From:
Sent: 05 August 2024 17:50
To: DCAdmin
Subject: Planning application 2024/91906

Erection of infill extension and alterations (within a conservation Area)

219 Abbey Road, Shepley, Huddersfield HD8 8AB

EXISTING FIRST FLOOR PLAN
1:50

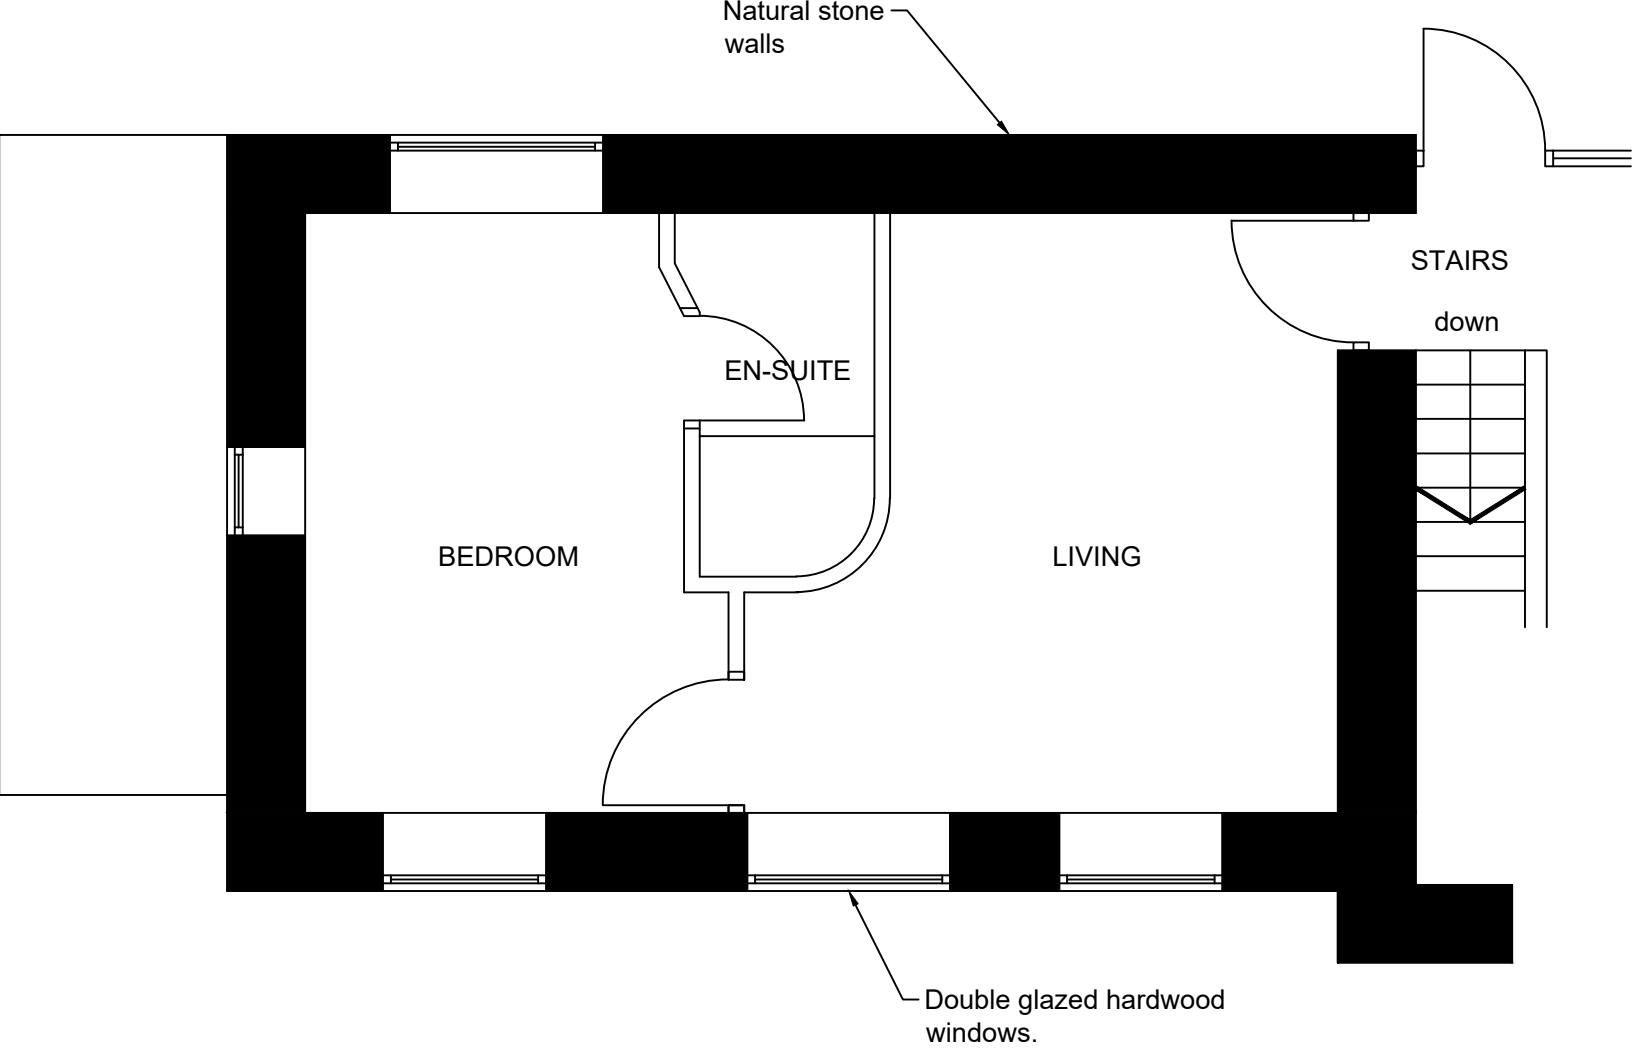
- The location plan [id 1050496] The area abutting both Abbey Road and Lea Drive is I believe could be under the curtilage of a different property on Abbey Road that has recently been sold unless of course they sold the land separately.
- The proposed Floor Plans[id1049026] 08 – First Floor When you look at the plans they are marked as Existing First Floor Plan
